**ExQ2: 03 August 2021****Responses due by Deadline 7: 03 September 2021**

<b>ExQ2</b>	<b>Question to:</b>	<b>Question:</b>
<b>DCO.2 Draft Development Consent Order (DCO) – comments on the Applicants’ responses to ExQs1 (all para numbers are prefixed DCO.)</b>		
DCO.2.0	The Applicant, ESC, SCC, Natural England, MMO	Attention is drawn to the Commentary on the DCO which includes commentary on the Deed of Obligation
DCO.2.1	Applicant, Environment Agency	1.35; “The reason for the inclusion of the specific exemption is that the Applicant proposes to divert an existing main river, Middleton Watercourse, as part of the construction of the Sizewell link road. Such a diversion will involve interference with the bed or banks of a main river”. Should the article not therefore be limited to the Middleton Watercourse?
DCO.2.2	Applicant	1.36. It would be helpful to warn that silence is deemed to be consent in that case.
DCO.2.3	Applicant, Maritime and Coastguard Agency	1.43 – please provide an update on the position. The SoCG indicated much work had yet to be done.

DRAWING NO:
SZC-SZ0100-XX-000-DRW-100205

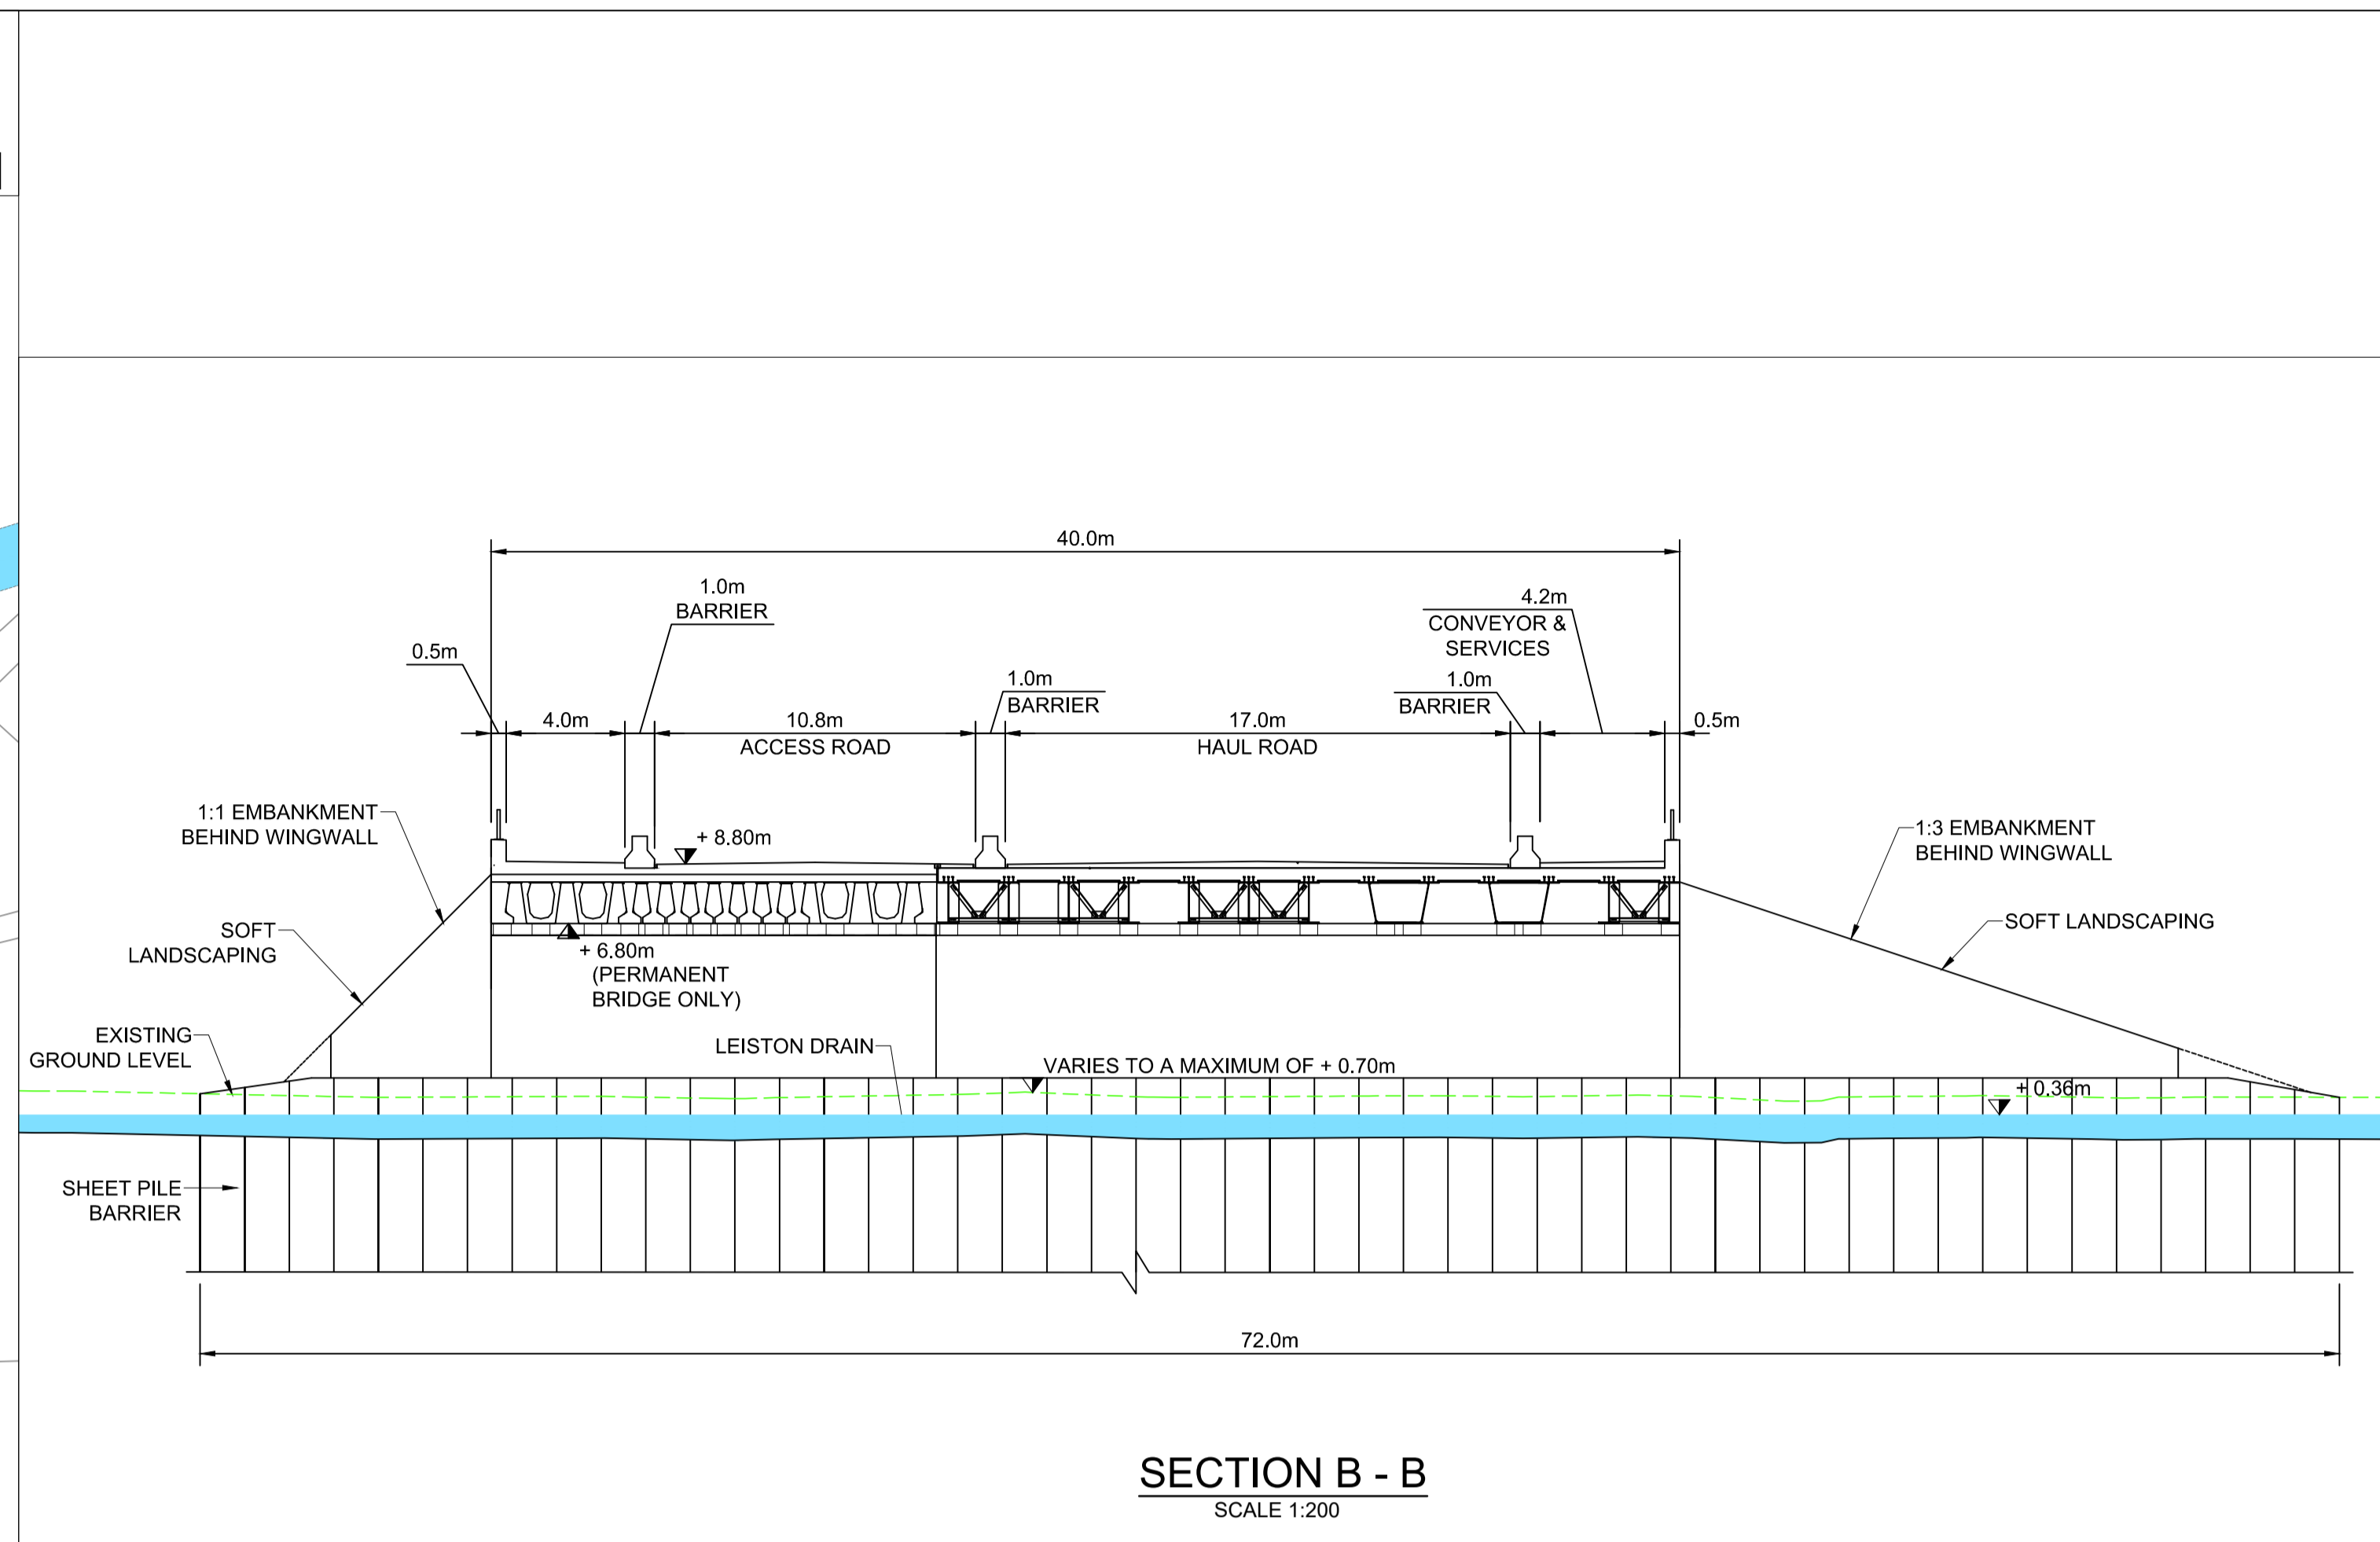
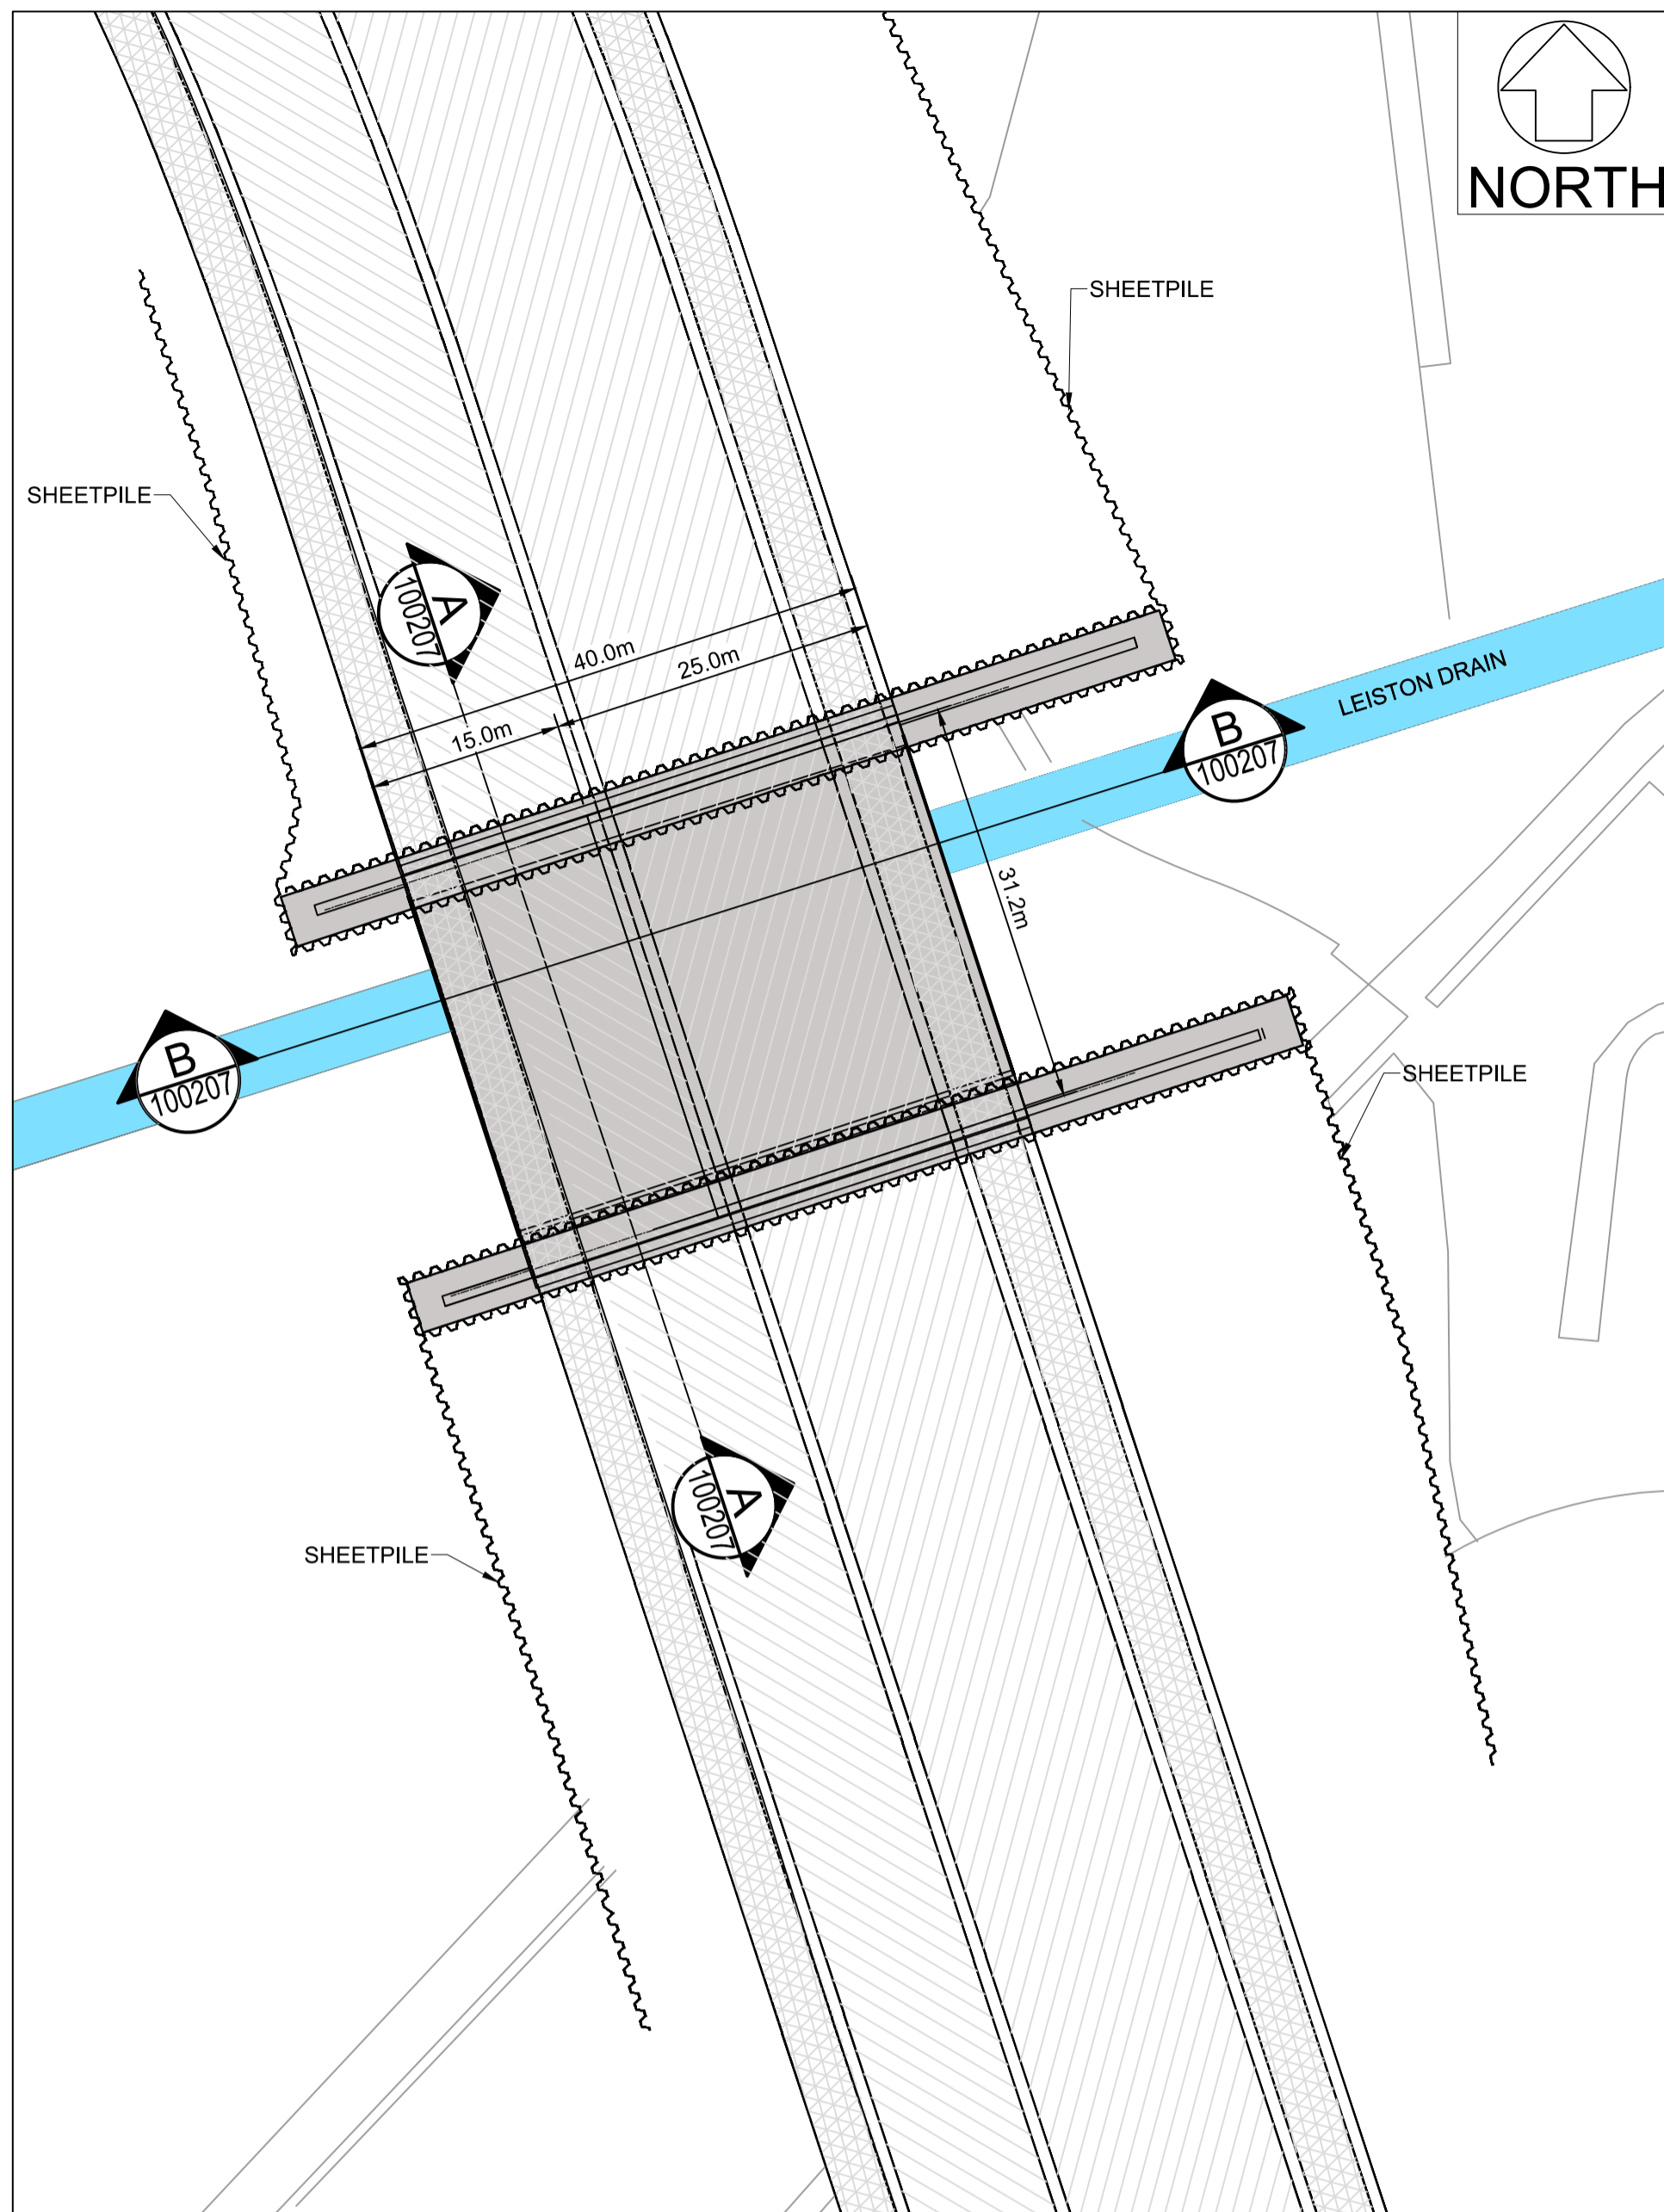
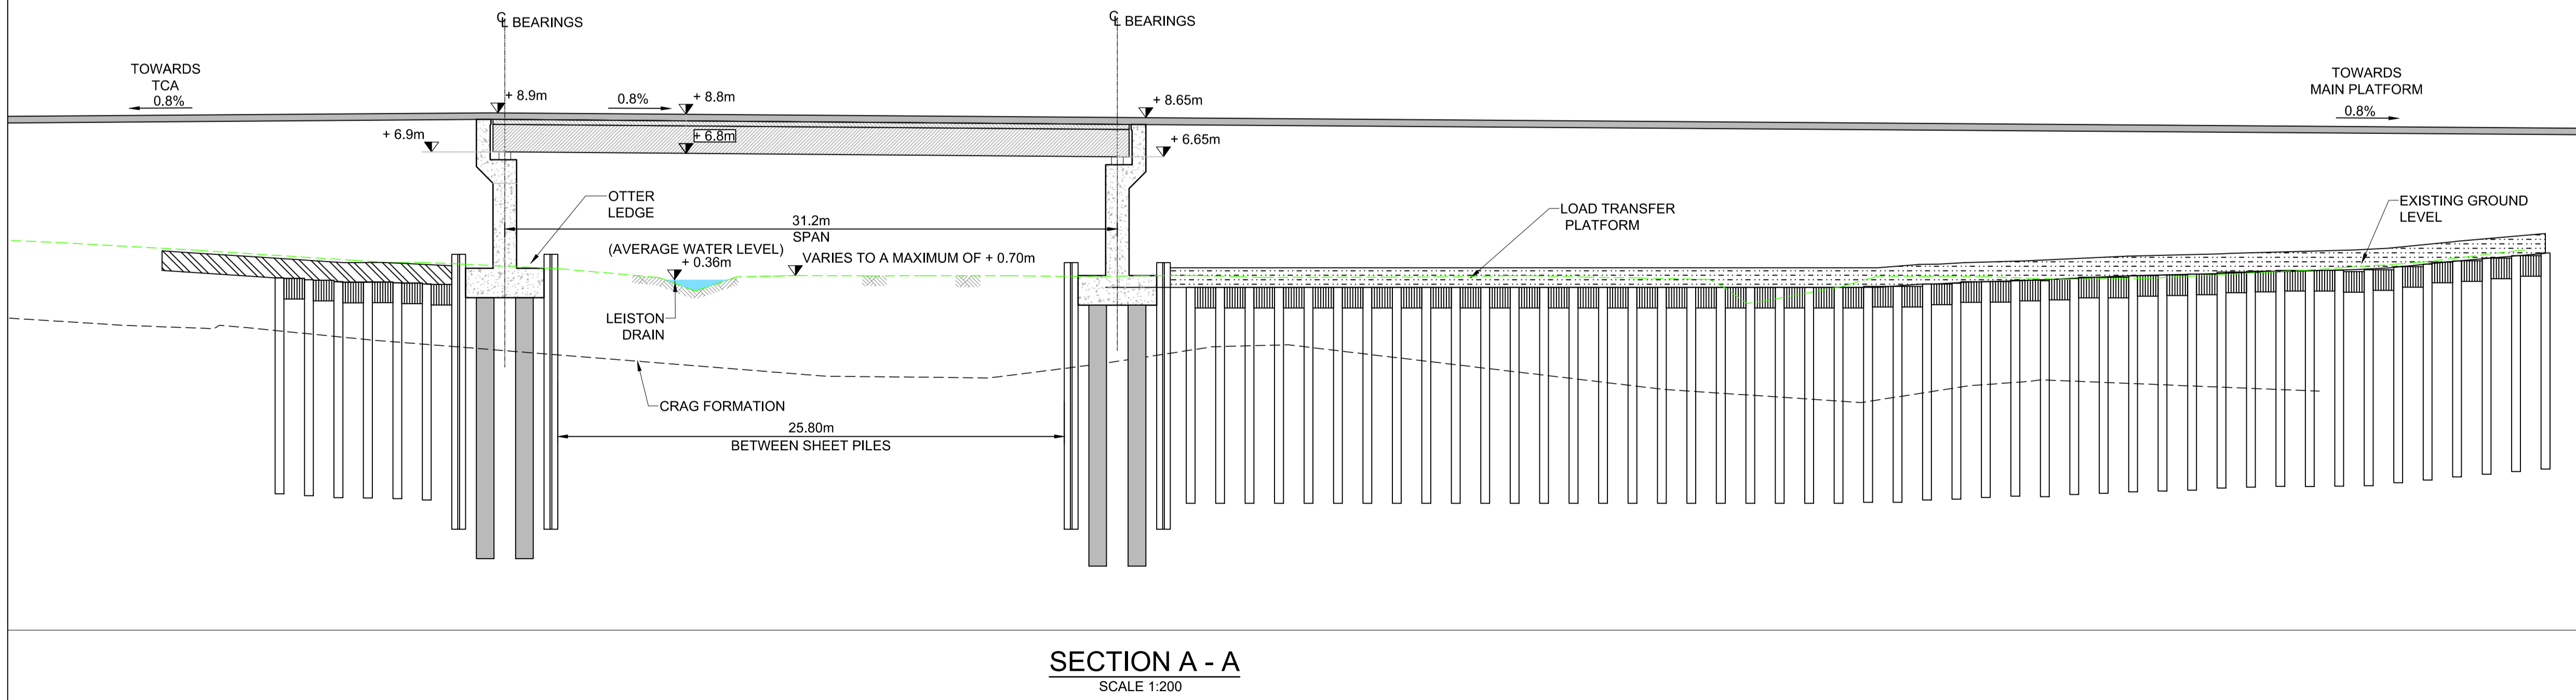
LI.2.4	ESC, SCC	<b>Design Review Panel</b> Paragraph 1.4.18 of [REP5-110] confirms that the design review panel would be used to provide independent support for the processing of design submissions defined by the requirements. Are you content with the proposed timing of the role?
LI.2.5	The Applicant	<b>Design Guardianship Role</b> The proposed retention of key members of the design team in a 'design guardianship' role is noted [REP5-110]. Please confirm what consultation on this role has been and what the securing mechanism for the role would be?
LI.2.6	The Applicant, Pro Corda, English Heritage Trust	<b>Leiston Abbey – Landscape Strategy/Masterplan</b> Noting the responses made in respect of ExQ1 LI.1.124 [REP3-046], please provide an update of discussions regarding a proposed whole site landscape strategy/masterplan.
LI.2.7	ESC, SCC, Natural England, The AONB Partnership, Stop Sizewell C, TASC	<b>SSSI Crossing – Design Amendment</b> Please review the amended SSSI crossing design [REP5-010] and provide comment.

LI.2.8	The Applicant	<b>SSSI Crossing – Design Amendment</b>

<b>ExQ2</b>	<b>Question to:</b>	<b>Question:</b>
		Please confirm what assessment has been undertaken in respect of potential landscape and visual impact(s) due to the amended design of the SSSI crossing [REP5-010]. In addition, please provide visualisations which clearly depict the proposed sheet pile barrier.
LI.2.9	The Applicant, ESC, Natural England, The AONB Partnership, Stop Sizewell C, TASC	<b>Alternative Outage Car Park Note</b> Please review and comment on the content of the SCC submission [REP5-171].
LI.2.10	The Applicant	<b>Outage Car Park</b> Noting the content of paragraph 4 of SCC's Alternative Outage Car Park note [REP5-171], please provide further detail as to why, if an outage clash occurs, clashes would continue until another forced or unplanned outage.
LI.2.11	The Applicant	<b>Outage Car Park</b> Please explain why a softer palette of surface finish materials is proposed for the outage car park (paragraph 8.8.18 of REP5-073)?
